RE: SSD 7382 MOD 3 – UTS Central – Response to Submissions

We write with regard to modification application SSD 7382 MOD 3 relating to the extension of Building 1 and the redevelopment of Building 2 (CB02) (otherwise known as UTS Central) at the Broadway Precinct of UTS. The modification request relates to design development changes and includes the following items:

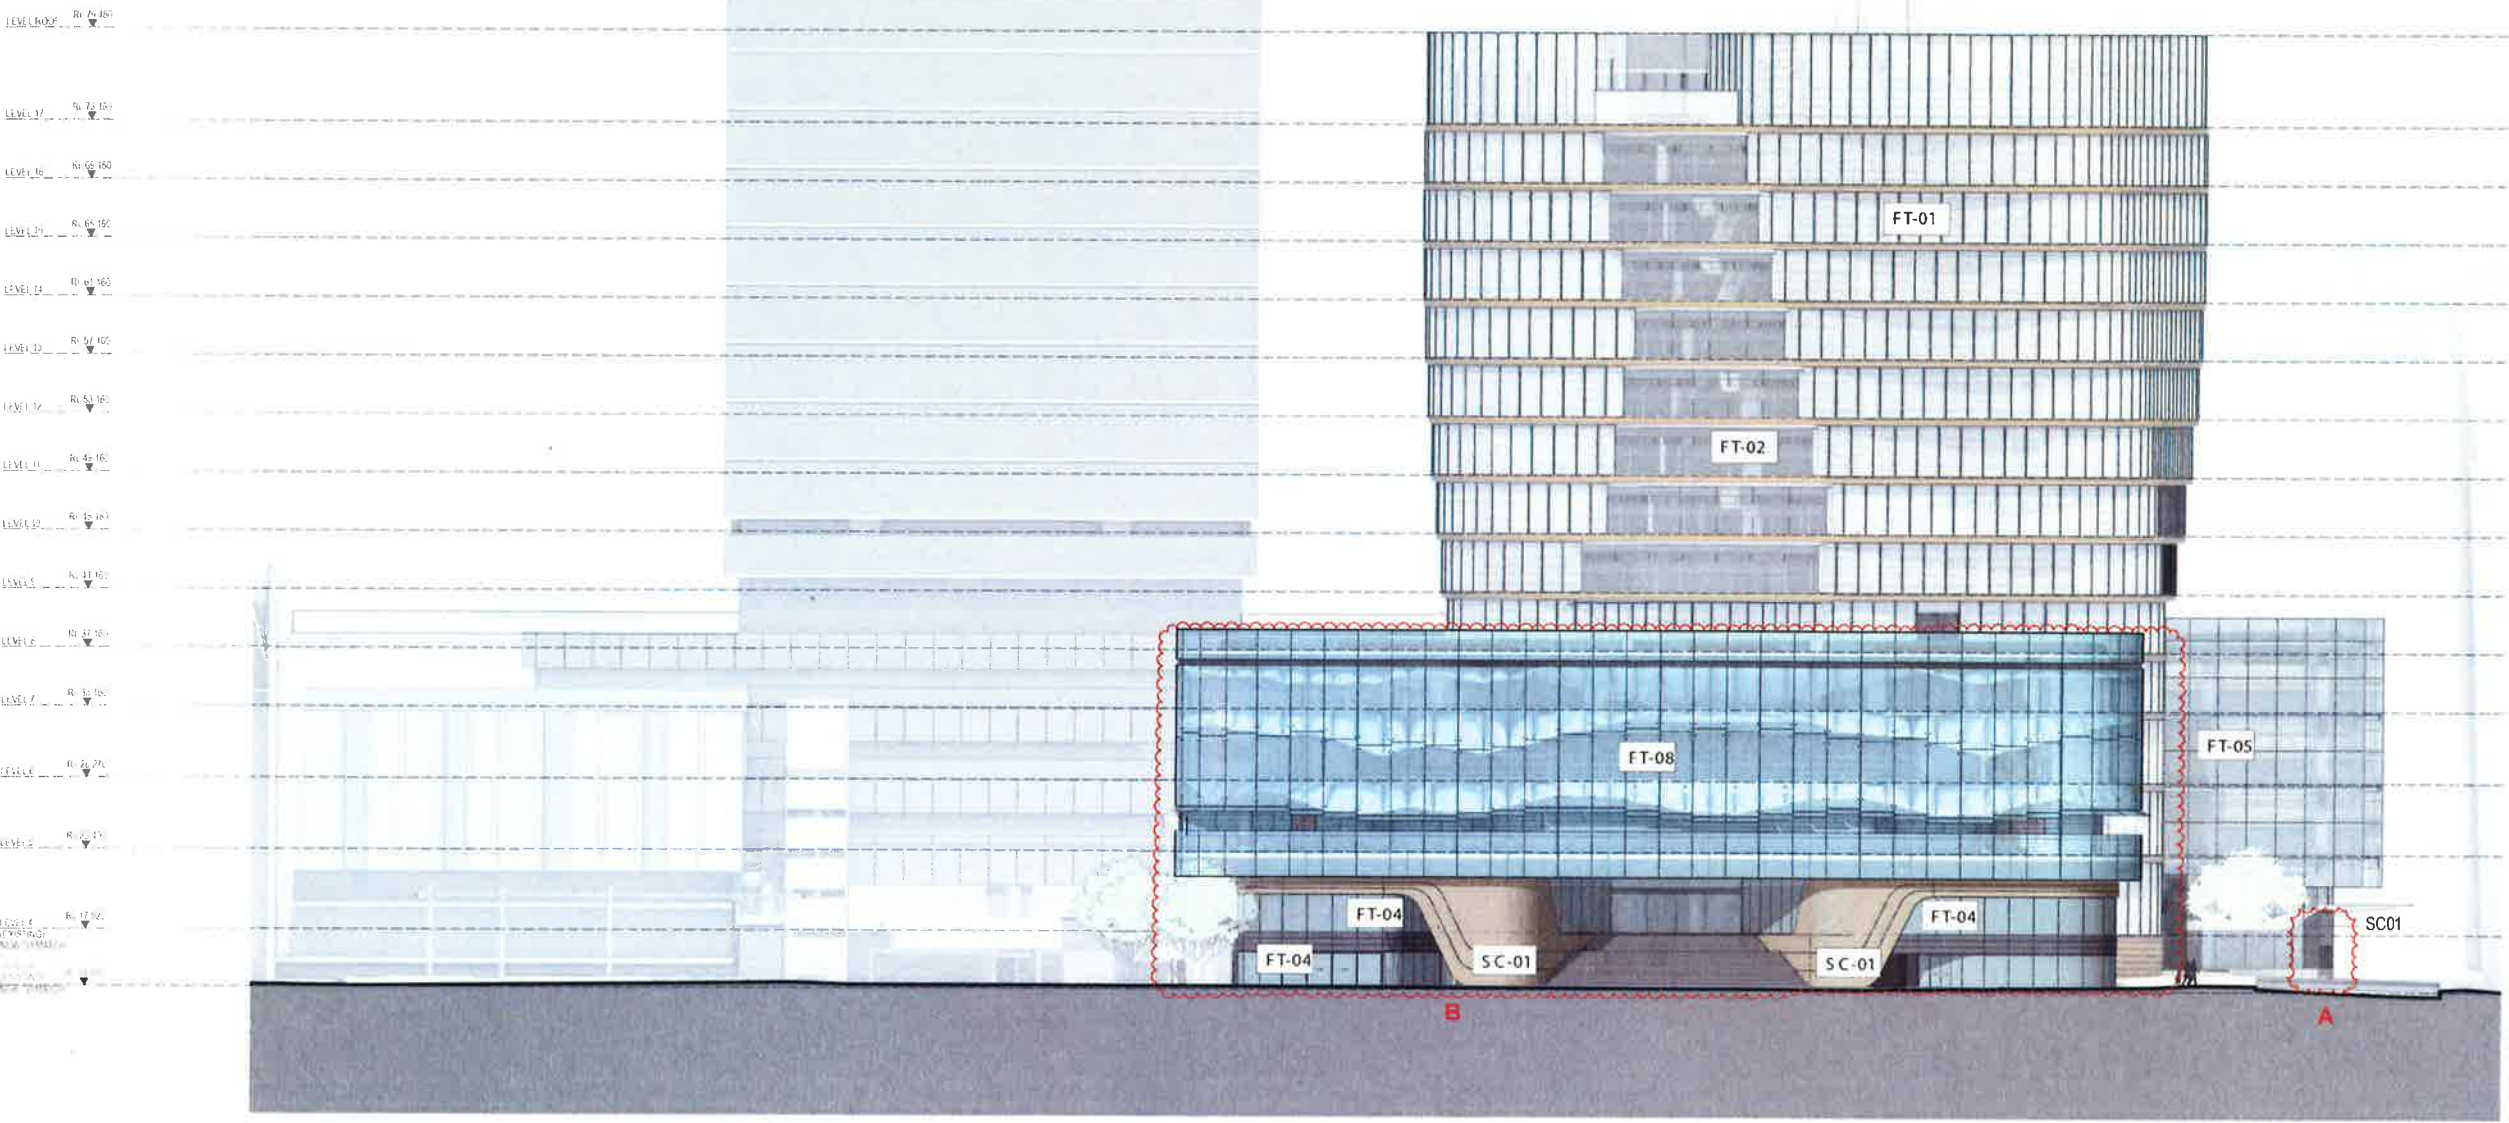
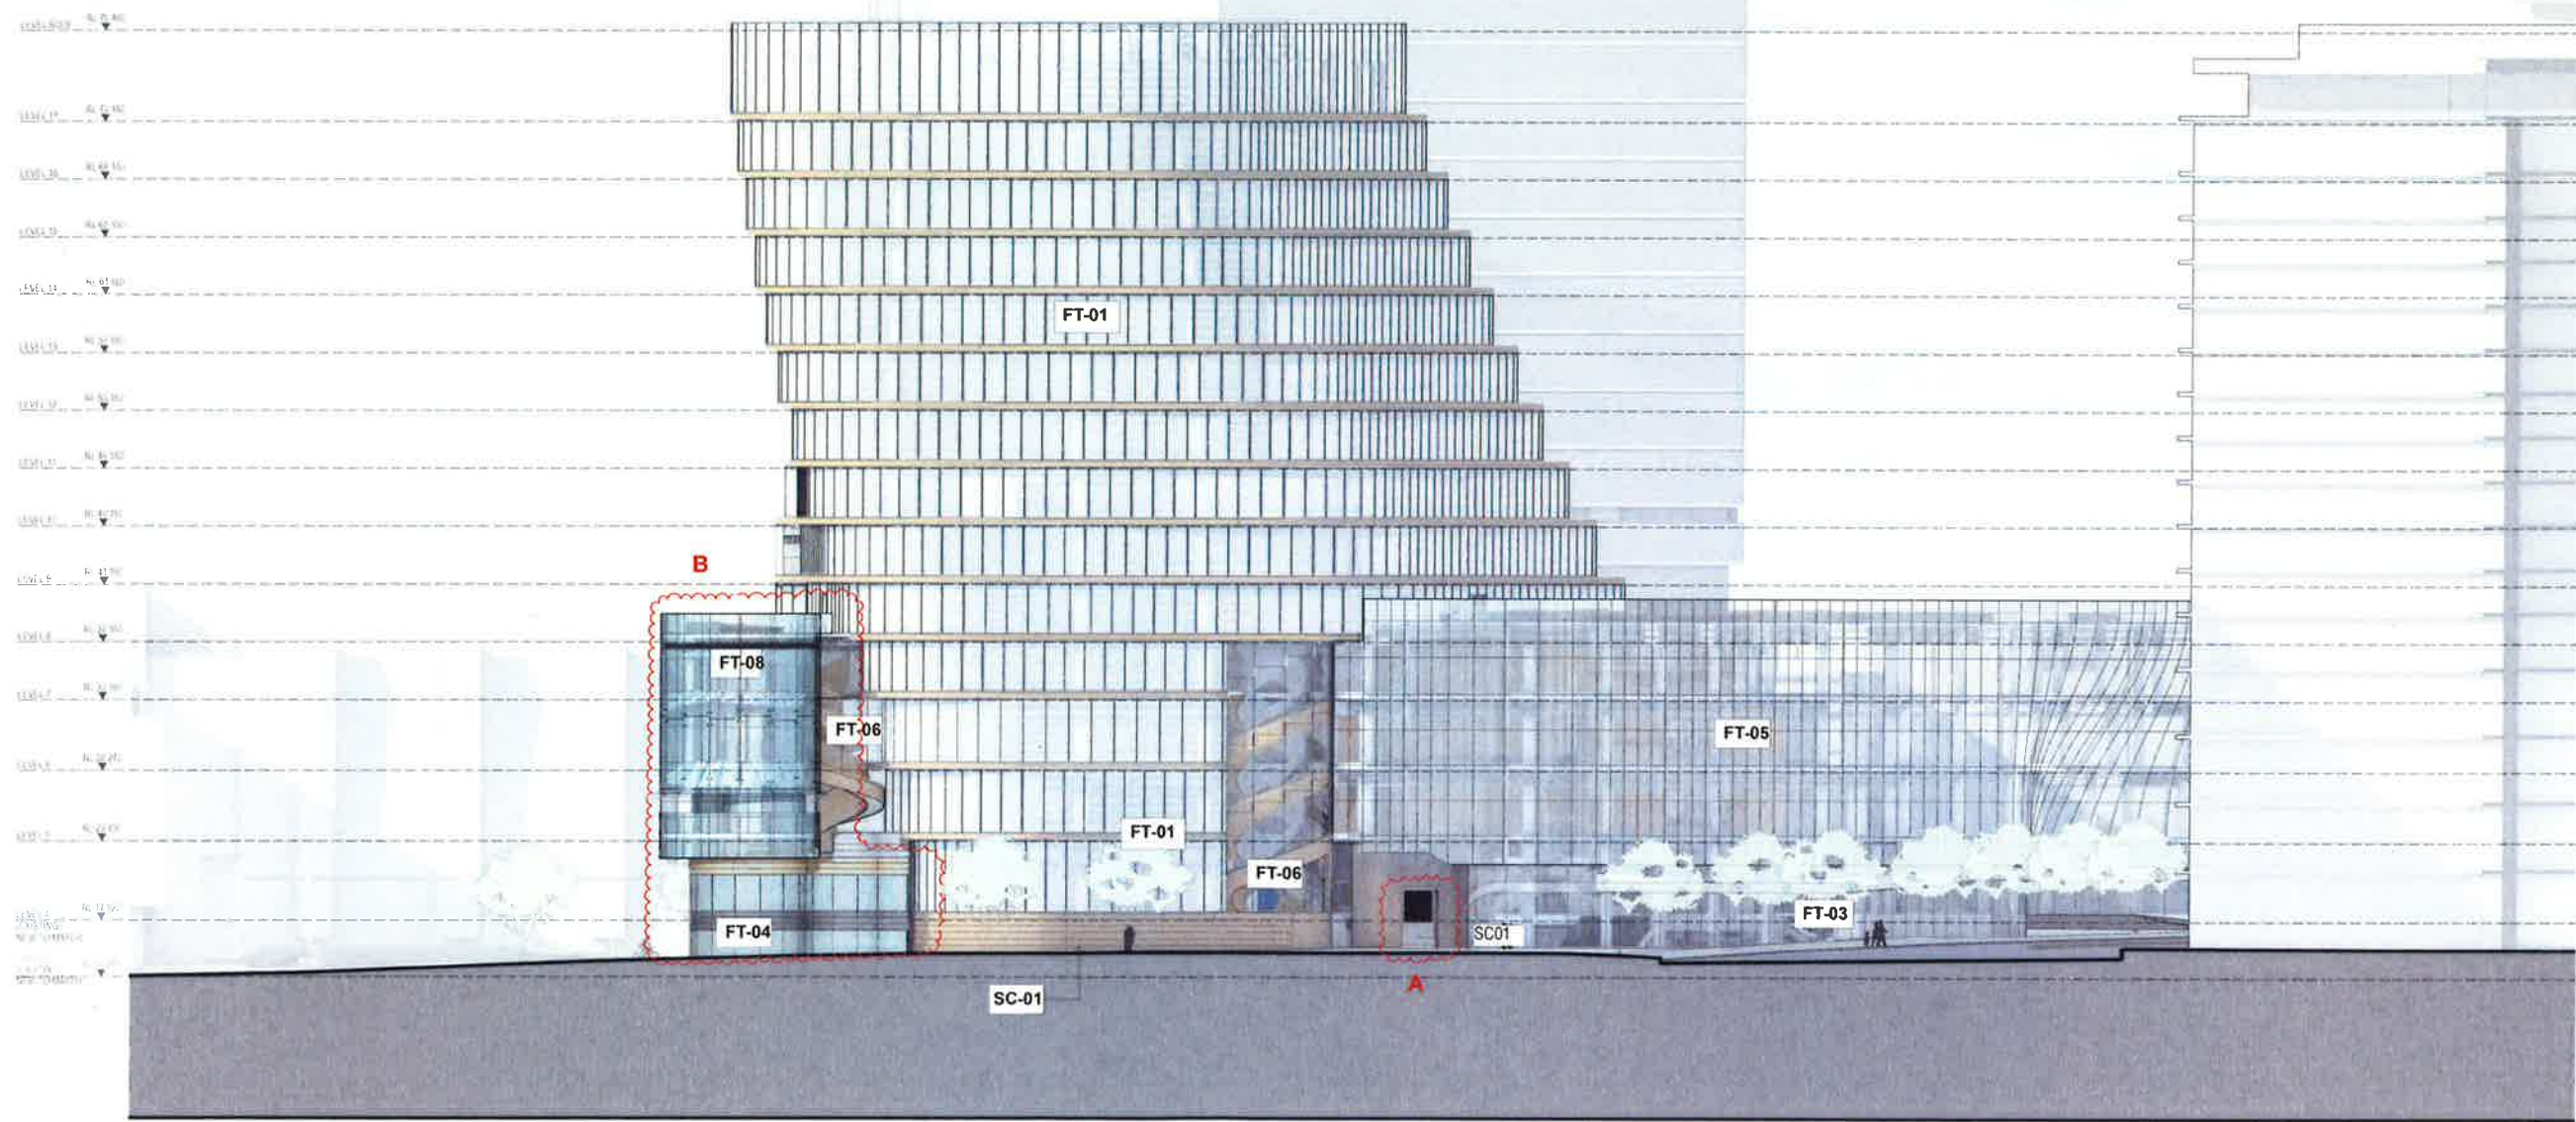
Based on the information provided, concerns are raised that both ventilation shafts are not well integrated with the design of the building. In particular, the stand-alone intake ventilation stack at 5m tall is a prominent and unsightly addition within the public domain. The Department are encouraged to require further investigations be carried out for a more suitable located and/or design for the shafts.

Council's concerns are acknowledged. The proposed approach to accommodating this essential piece of infrastructure for the project has not been taken lightly and is the result of an exhaustive consultation and design process with Ausgrid, services engineers, and the project architects and landscape designers.

The location of the ventilation stacks is restricted to the proposed location due to relevant Ausgrid requirements, which require clearances between and from both the exhaust and intake for the substation, the entry of the building and the position of the substation below Jones Street (refer to **Figure 1**, with further diagrams demonstrating

In accordance with Ausgrid requirements, the transformer in the substation cannot be more than 10m from the top of the louvres which sets a maximum vertical distance for where the ventilation stacks are located. There also cannot be less than 6m between intake and exhaust for the substation and no less than 3m between the intake/exhaust and the entry on Jones Street. All these factors together have led to the design approach being adopted.

Every effort has been made to minimise the visual impacts associated with the intake ventilation stack, including adopting a curvilinear shape to the stack (as opposed to the bulkier standard rectilinear stacks) together with applying a rendered and painted finish that is consistent with the base building – enabling the stack to blend into the background (especially when viewed from Broadway where the stack will be visible in the foreground of a solid wall) (refer to updated elevation at **Attachment B**). The stack also has an additionally functional purpose in providing the structure for holding the handrail associated with the proposed steps.

During the response to submissions stage of this modification application, a further change was made to the materials of the façade facing Alumni Green. Under the initial plans submitted with the modification application, the materials of the façade adjacent to the steps fronting Alumni Green were proposed to comprise natural sandstone panels on proprietary sub framing or stub wall. This material has been revised to now comprise paint finish to rendered finish on masonry wall. The area in question is annotated 'SC-01' in **Figure 4** below.

The change in materials is primarily due to buildability and the ongoing maintenance and long term durability of the finish. This facade has also been articulated to have the same dimensional setout of the slab edge fascia of the tower and is also consistent with the facade panel joints on Alumni Green. As outlined above, the material of the substation ventilation shaft on Jones Street match the amended materials on the façade of the building.
